WEST SUSSEX COUNTY COUNCIL CONSULTATION

TO:	Arun District Council FAO: Maria Tomalova
FROM:	WSCC - Highways Authority
DATE:	29 April 2022
LOCATION:	Holmlea, Main Unit Rear Of Town Cross Avenue, Bognor Regis, PO21 2DN
SUBJECT:	BR/82/22/PL Demolition of warehouse and proposed construction of 10 self contained apartments. This application is in CIL Zone 4 (Zero Rated) as flats.
DATE OF SITE VISIT:	N/A
RECOMMENDATION:	More Information
S106 CONTRIBUTION TOTAL:	N/A

Proposed Apartments
Planning

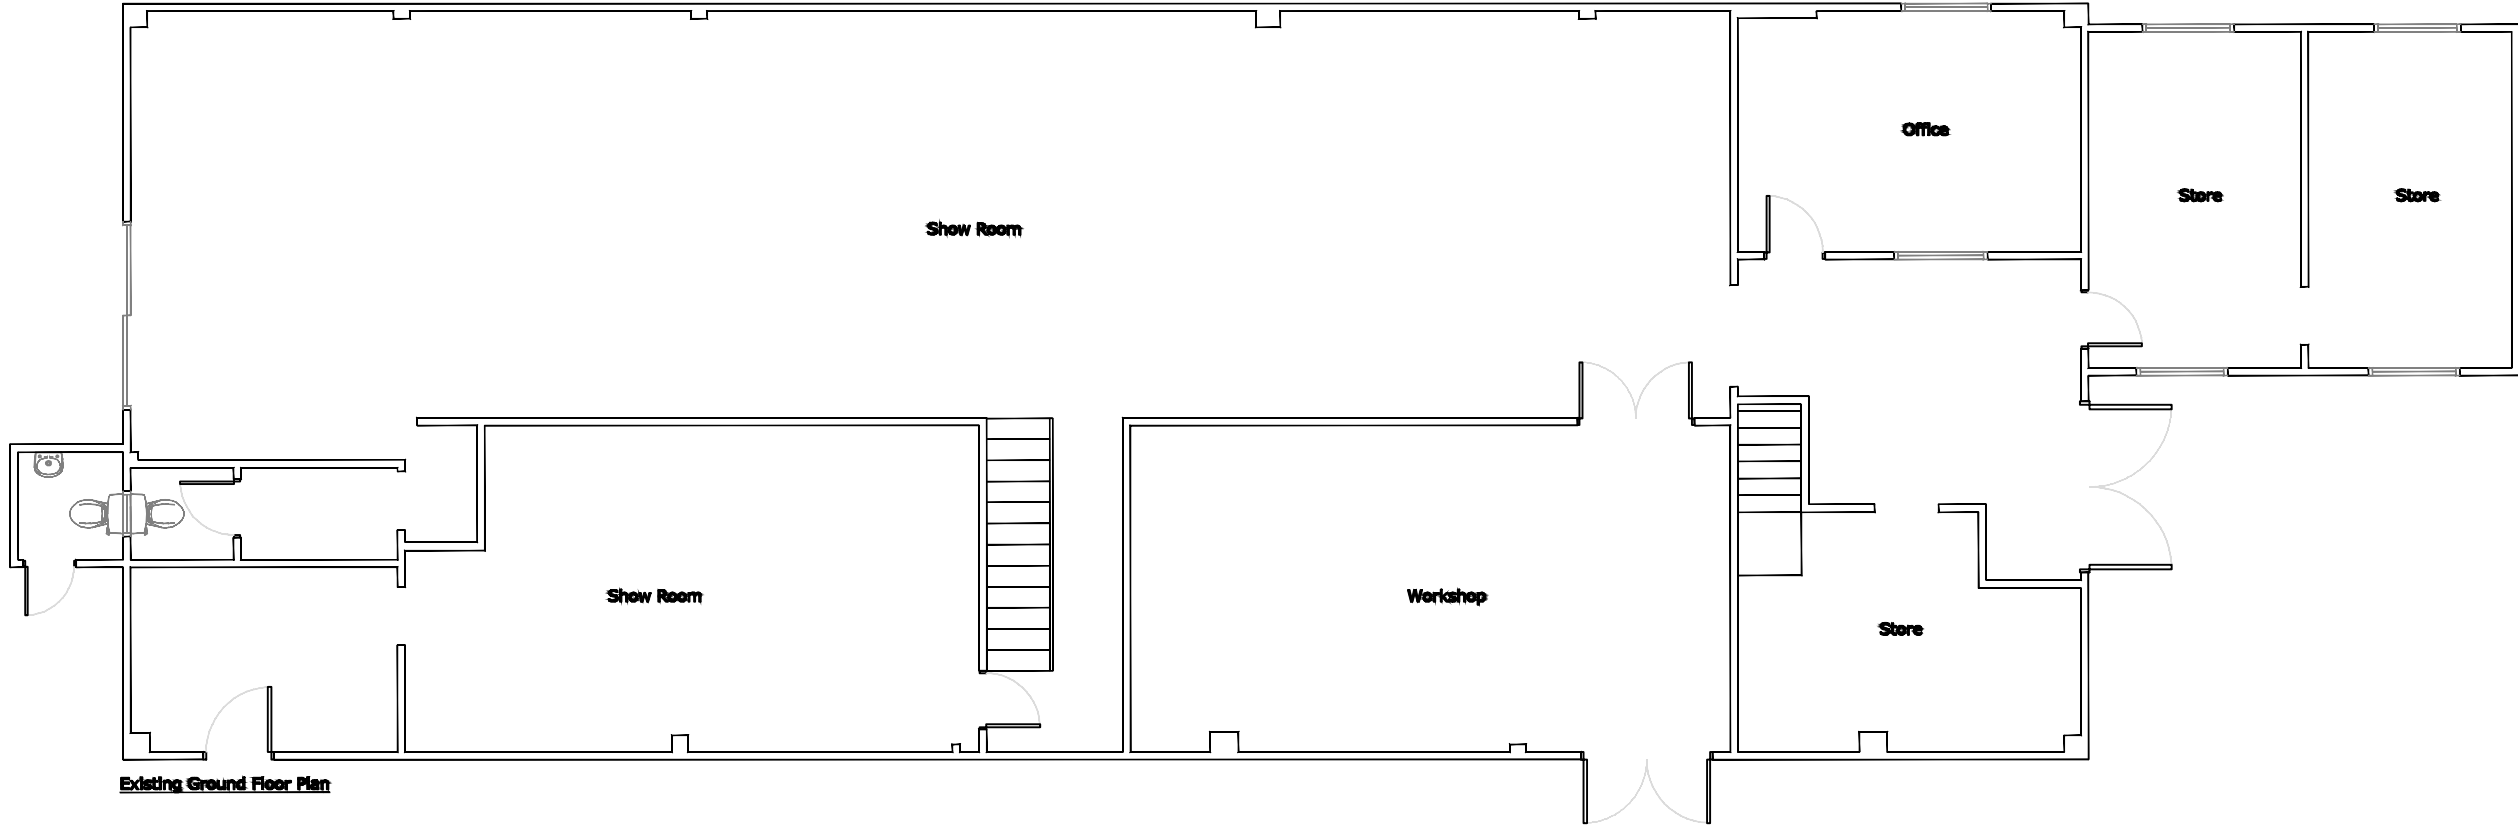
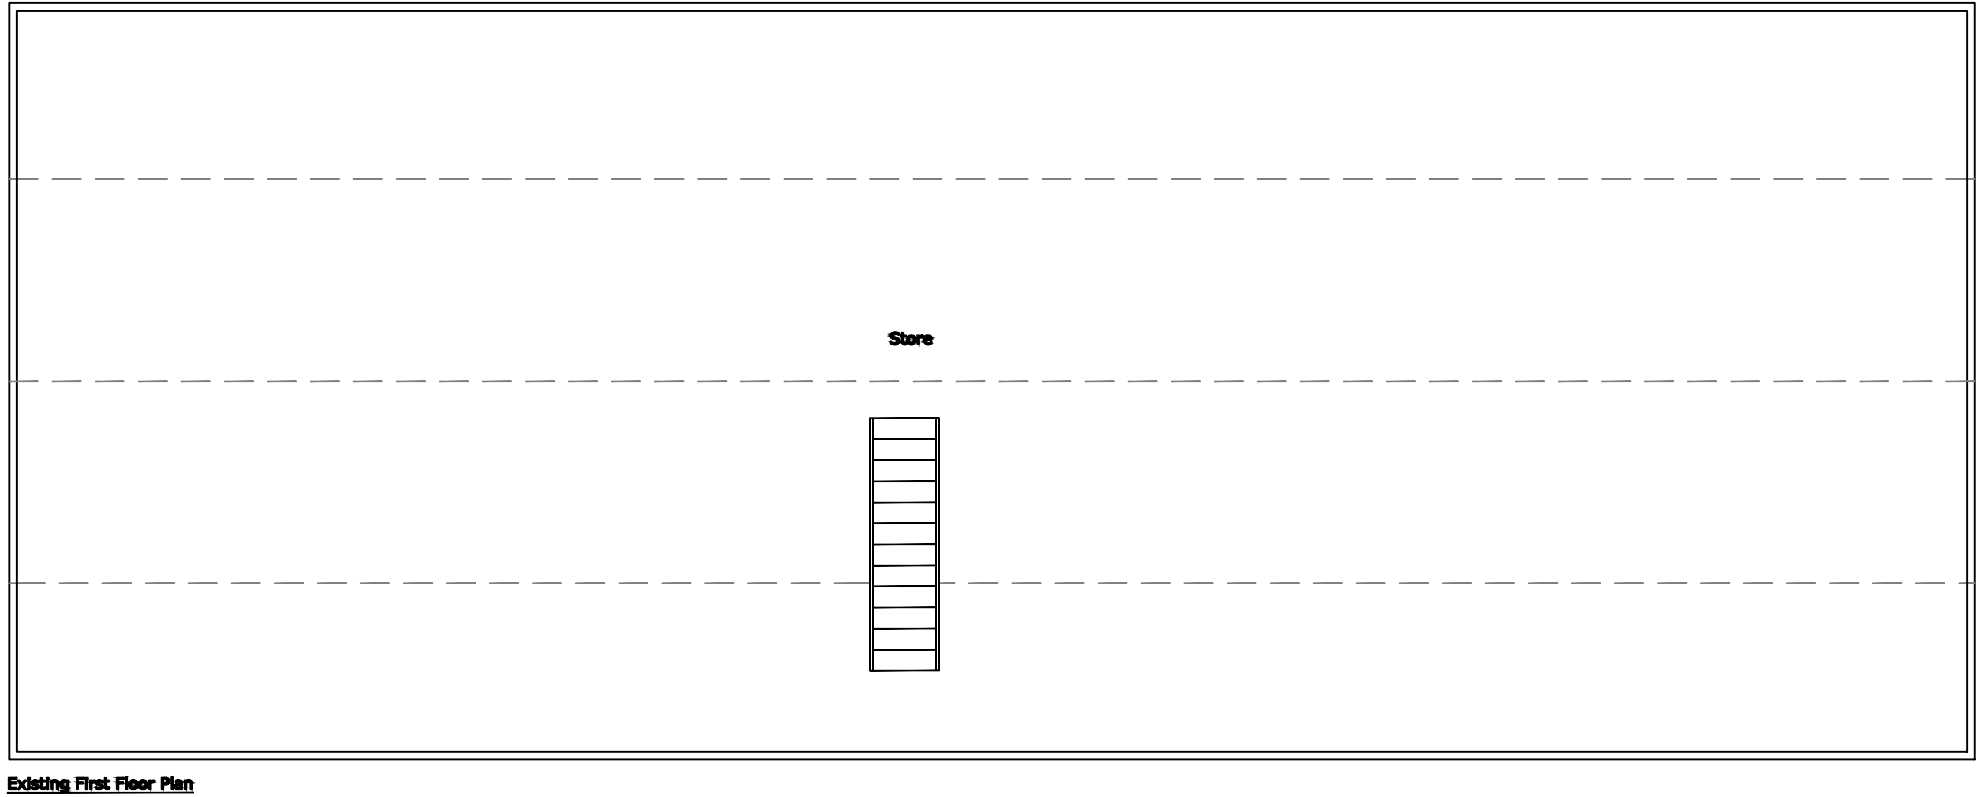
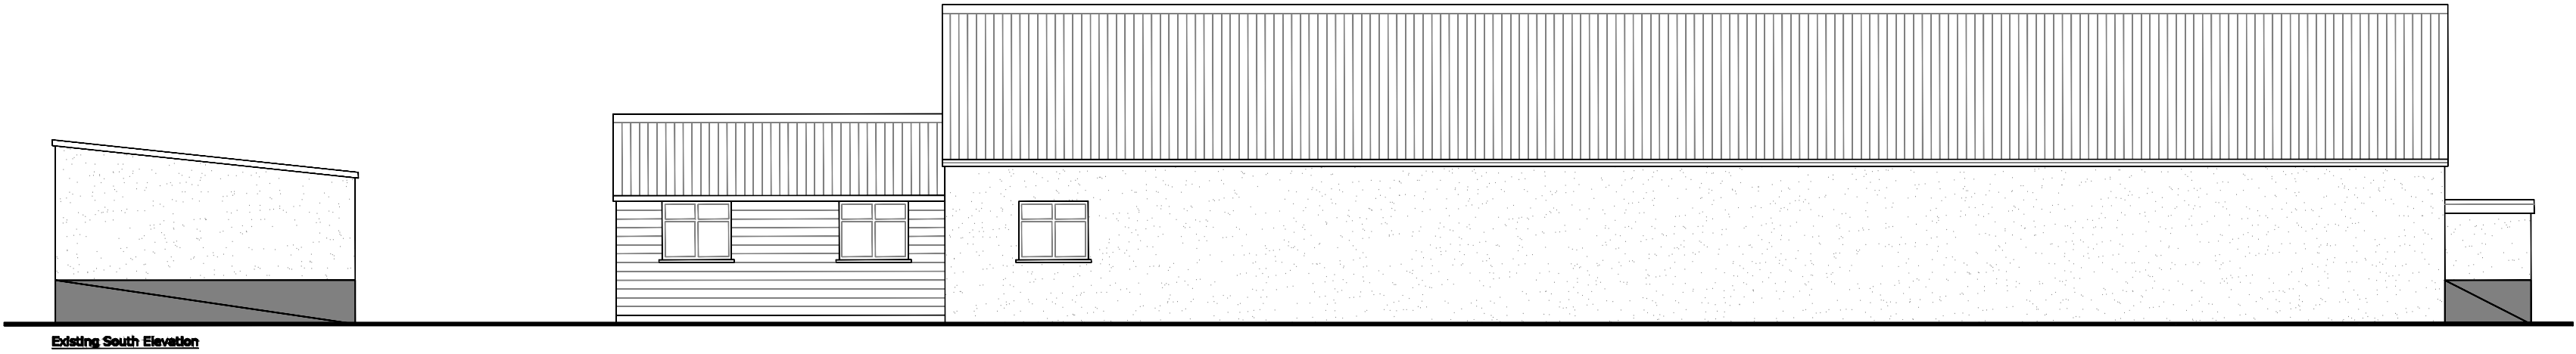
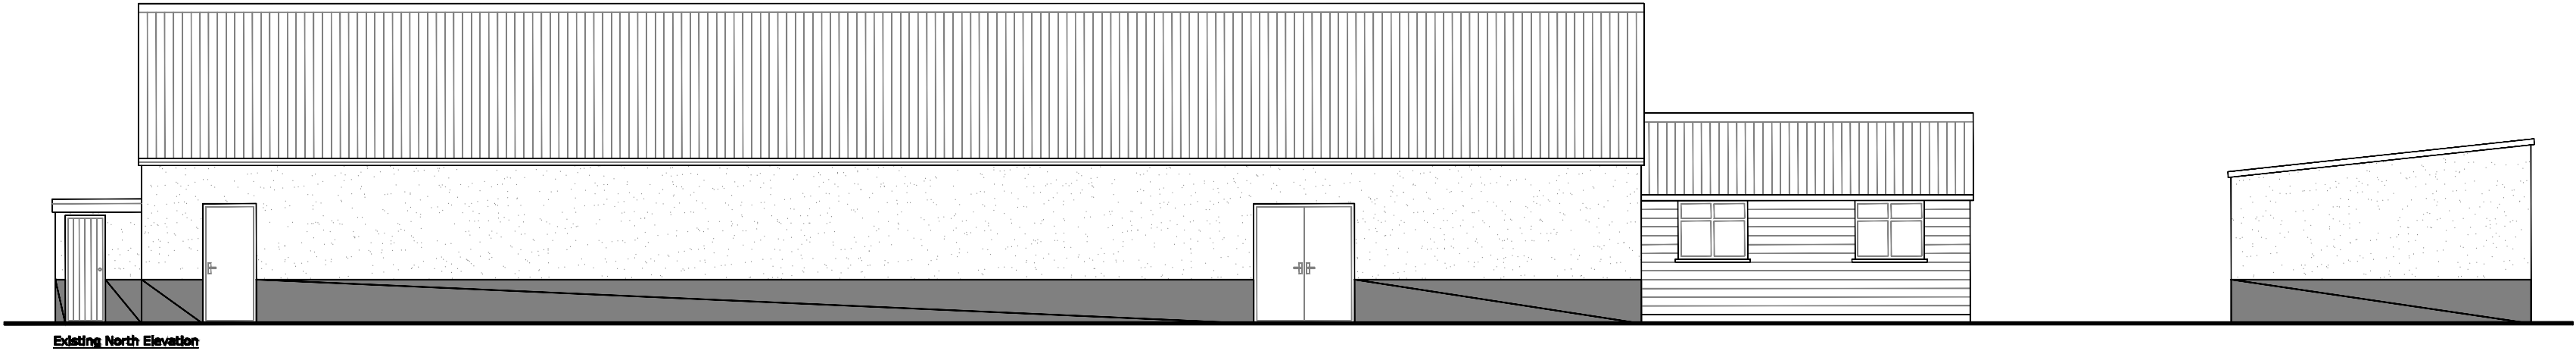
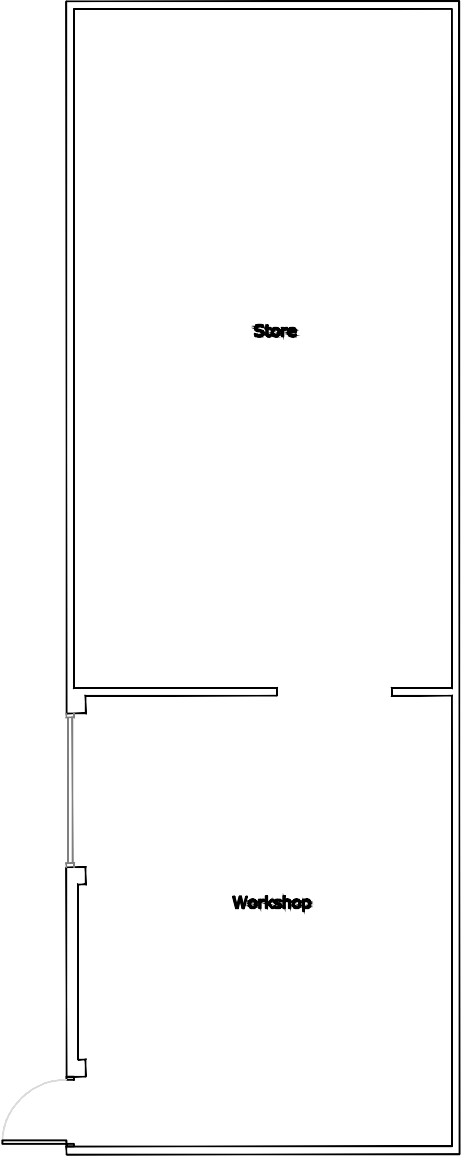
The applicant proposes to utilise the existing vehicular access on Town Cross Avenue. It is unclear from the submitted plans if a fire appliance or refuse vehicle can access and turn on-site safely, as no such demonstration has been provided. The LHA requests the applicant to demonstrate via swept path tracking that a fire appliance and refuse vehicle can safely access and egress the site, as well as turn on-site and exit on to the maintained highway in a forward gear.

The applicant proposes eight car parking spaces for this development. Under Arun Parking Standards, the LHA would expect a development of this size and location to provide at least ten car parking spaces. From inspection of the submitted plans, there may be scope to provide additional parking provision within the site in accordance with Arun Parking Standards. The applicant is advised to provide at least ten parking spaces for this development.

The Application Form states that ten cycle parking spaces are proposed. This is in accordance with Arun Parking Standards and the LHA is satisfied with the proposed amount in principle. However, the plans do not indicate the location of the proposed cycle parking provision. Therefore, the LHA requests the applicant to demonstrate the location of the proposed cycle parking.
